MERIDIAN ROAD & BENT GRASS MEADOWS DRIVE

GRADING AND EROSION CONTROL PLANS

MERIDIAN ROAD & BENT GRASS MEADOWS DRIVE
GRADING & EROSION CONTROL PLANS
FOR
CHALLENGER COMMUNITIES, LLC

COVER SHEET

C1.0

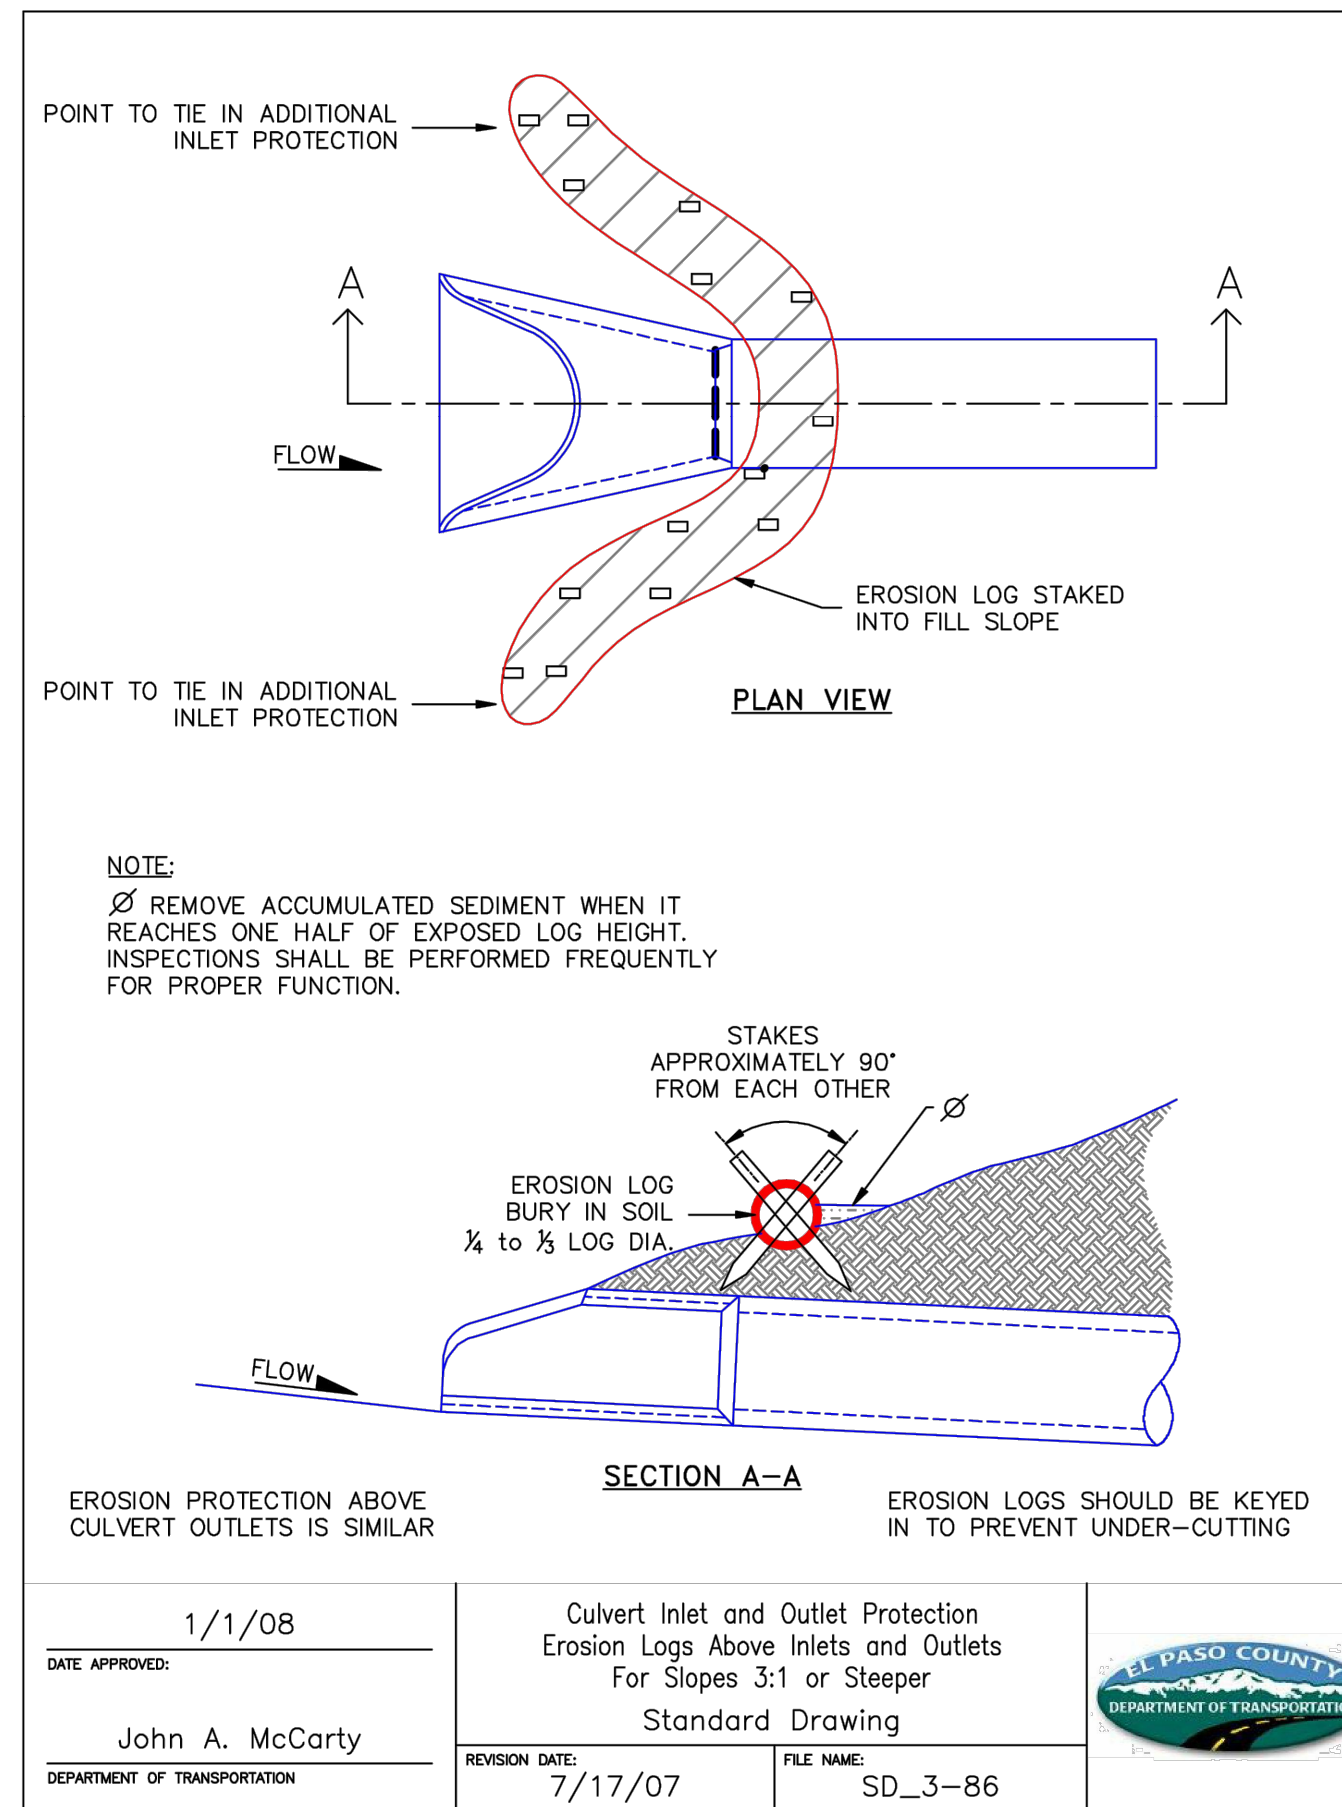
update notes in accordance with GEC Checklist Section 3.
Unresolved.

- CONCRETE WASH WATER SHALL BE CONTAINED AND DISPOSED OF IN ACCORDANCE WITH THE 409 WAS SURFACE OR SUBSURFACE STORM DRAINAGE SYSTEM OR FACILITIES. CONCRETE WASHOUT SHALL NOT BE DISCHARGED TO STATE WATERS, INCLUDING ANY STORMWATER MAY BE PRESENT, OR WITHIN 50 FEET OF A SURFACE WATER BODY. ADD: "creek or stream."

- IF STORMWATER FLOW IN THE FLOW LINE OF THE CURB AND GUTTER OR IN THE DITCH FLOW LINE ADD: "except with approved sediment control measures."
- OWNER/DEVELOPER AND THEIR AGENTS SHALL COMPLY WITH THE "COLORADO WATER QUALITY CONTROL ACT" (TITLE 25, ARTICLE 8, CRS), AND THE "CLEAN WATER ACT" (FEDERAL LAW, 33 USC 1251). THE REQUIREMENTS OF THE LAND DEVELOPMENT CODE, DCM VOLUME II AND THE EOM APPENDIX I. ALL APPROPRIATE PERMITS MUST BE OBTAINED BY THE CONTRACTOR. (NPDES, FLOODPLAIN, 404, FUGITIVE DUST, ETC.). IN THE EVENT OF CONFLICTS BETWEEN THESE REQUIREMENTS AND OTHER LAWS, RULES, OR REGULATIONS OF OTHER AGENCIES, THE MOST RESTRICTIVE LAWS, RULES, OR REGULATIONS SHALL APPLY.

NOTES REVISED IN ACCORDANCE WITH GEC CHECKLIST.
